Y/61/21/L

Willow Cottage Church Road Yapton BN18 0EW

Listed building consent to replace front door.

**2 Proposed Plans, Elevations and Photographs**

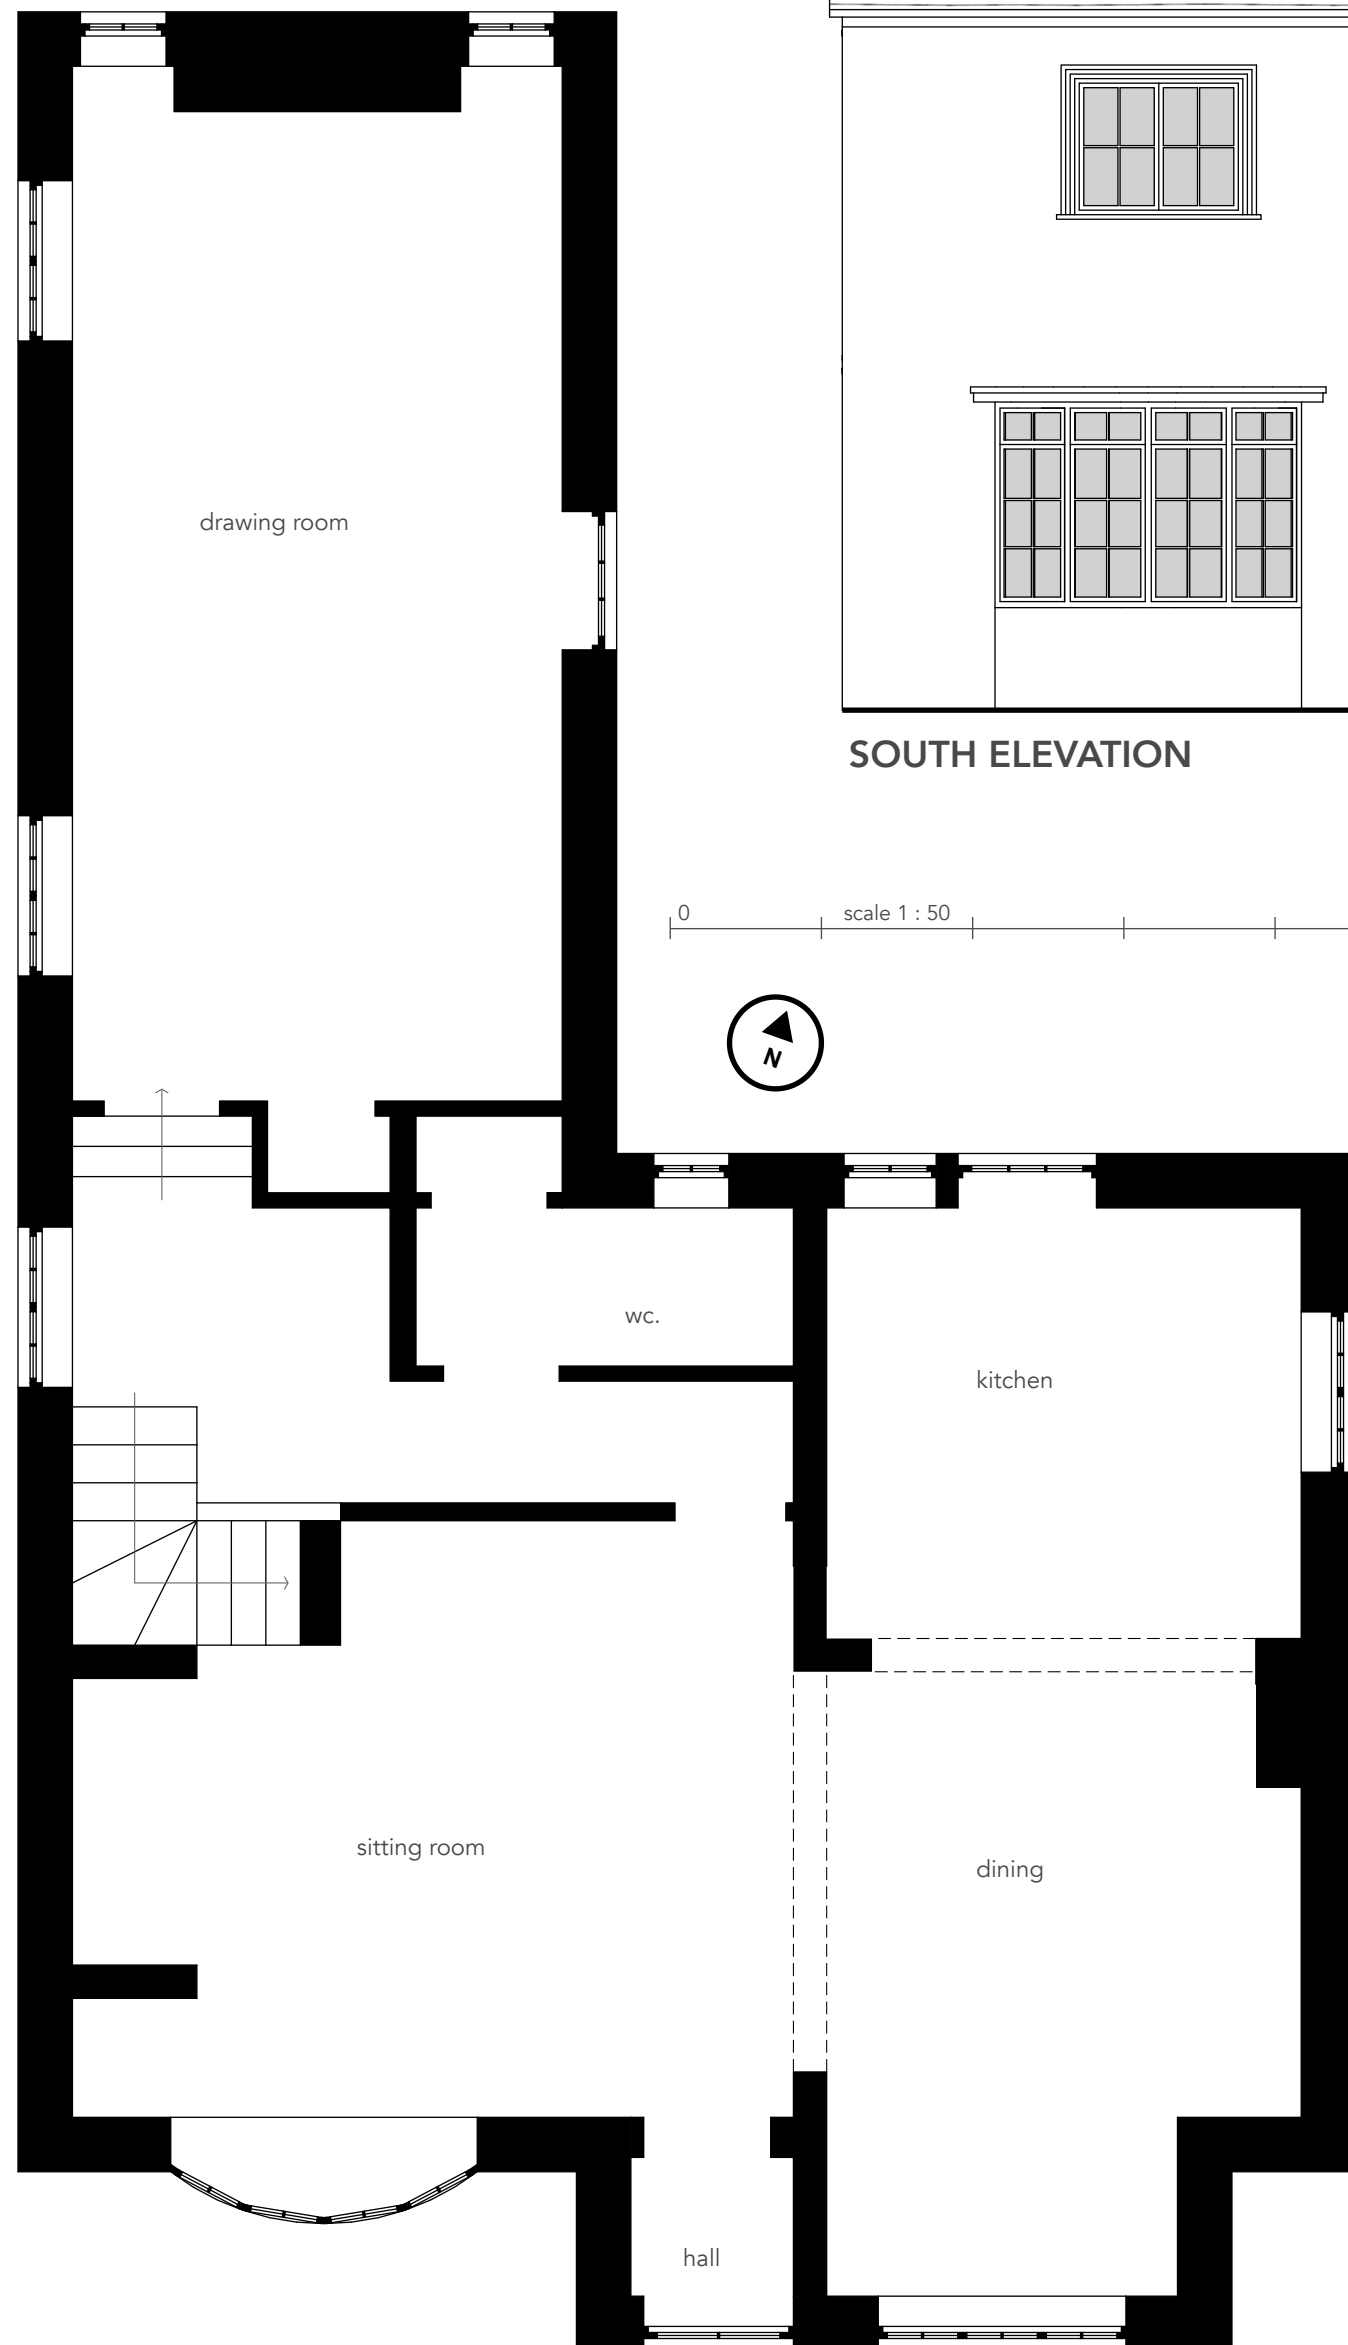
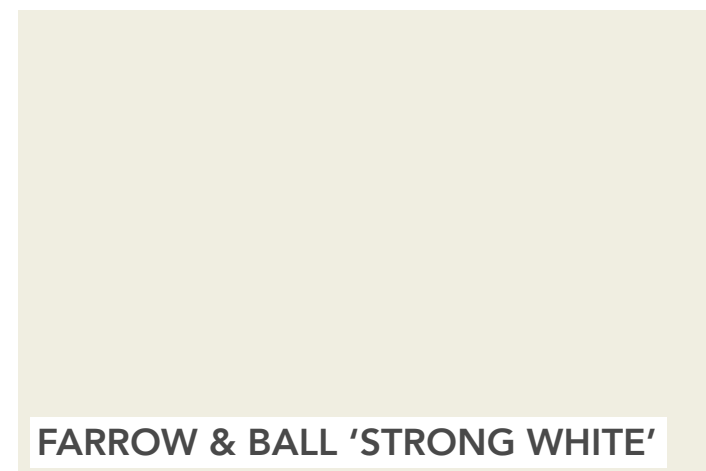
The proposal is to replace the existing dark coloured front door with what appears to be a pre-used one. It is noted that the existing front door is assumed to have been installed during the refurbishments which took place during the mid/late twentieth century. This door is not of significance and its replacement would be acceptable. The replacement door is of a traditional design and it is considered that it would not cause harm. Likewise, the proposed colour is acceptable.
